CITY OF ALBUQUERQUE

Planning Department
Suzanne Lubar, Director

**Re: The Baca Duplexes
4421 12th St NW
Request Permanent C.O. – Not Accepted
Engineer's Stamp dated: 7-8-14 (G14D080)
Certification dated: 10-7-15**

GRADING & DRAINAGE PLAN

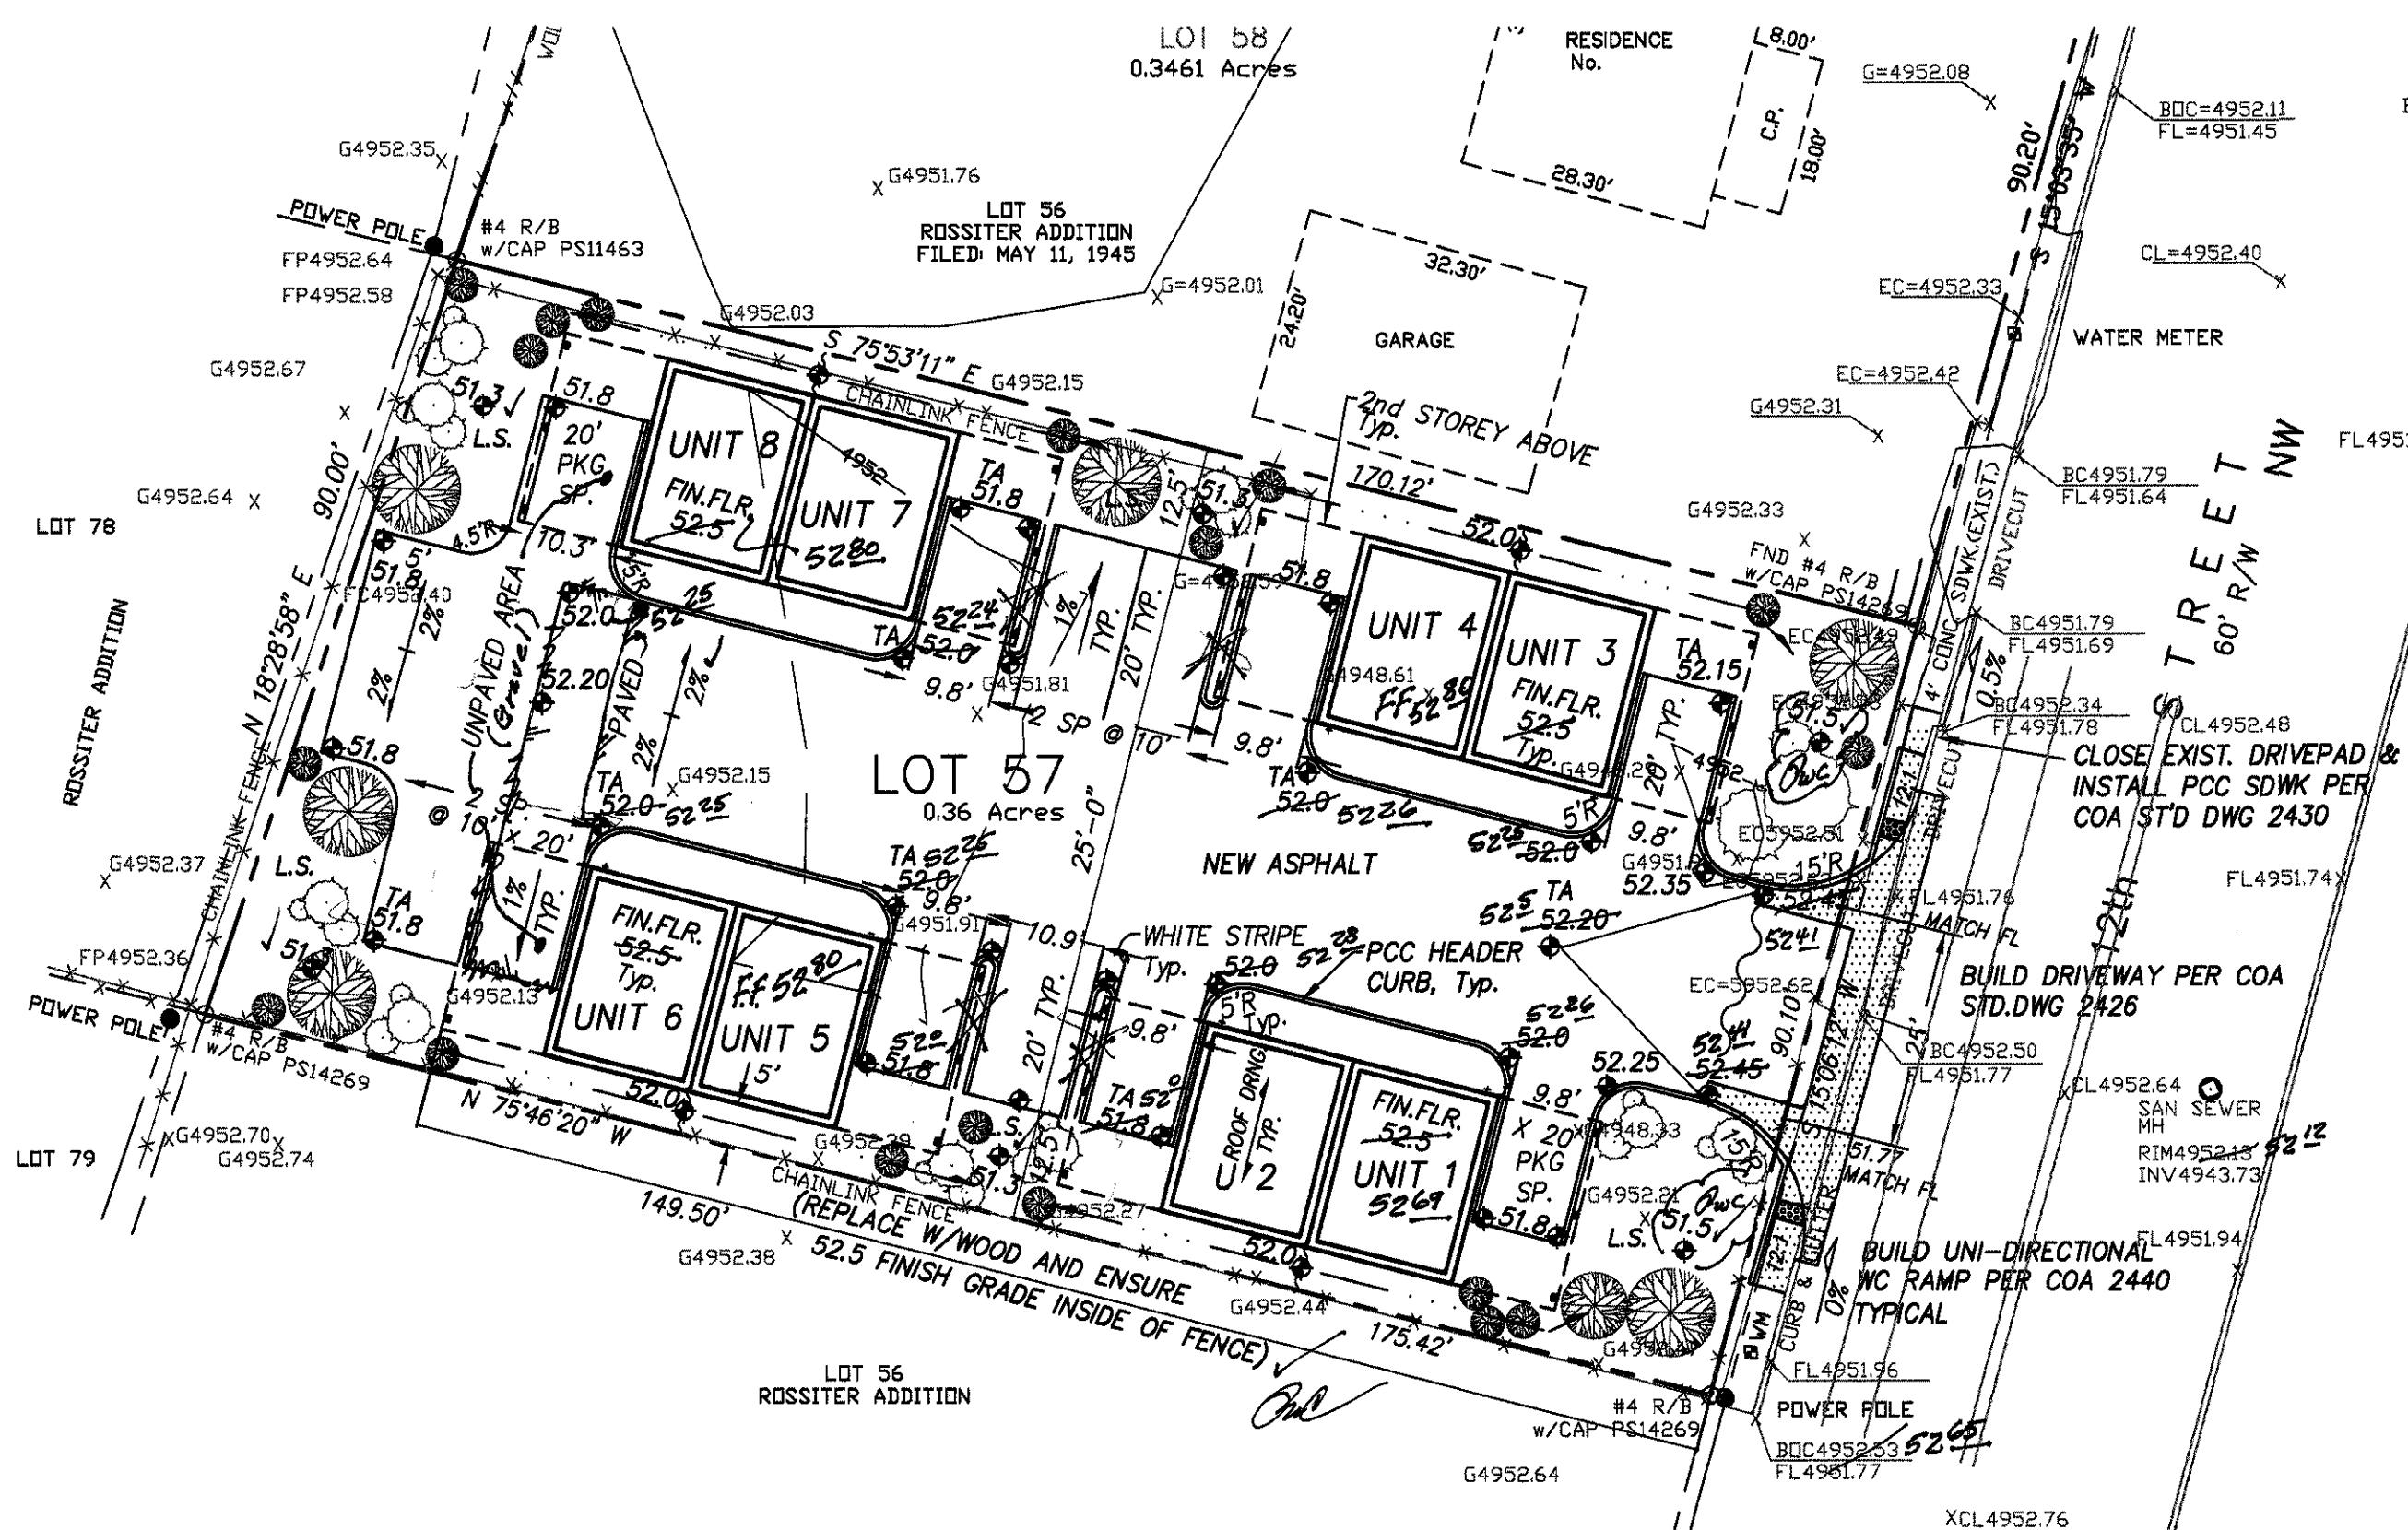
1. The site does not drain with substantial compliance; swales need to be added to the north and south of each duplex for drainage into ponds on the east and west.
2. Landscaping does not appear to be depressed.
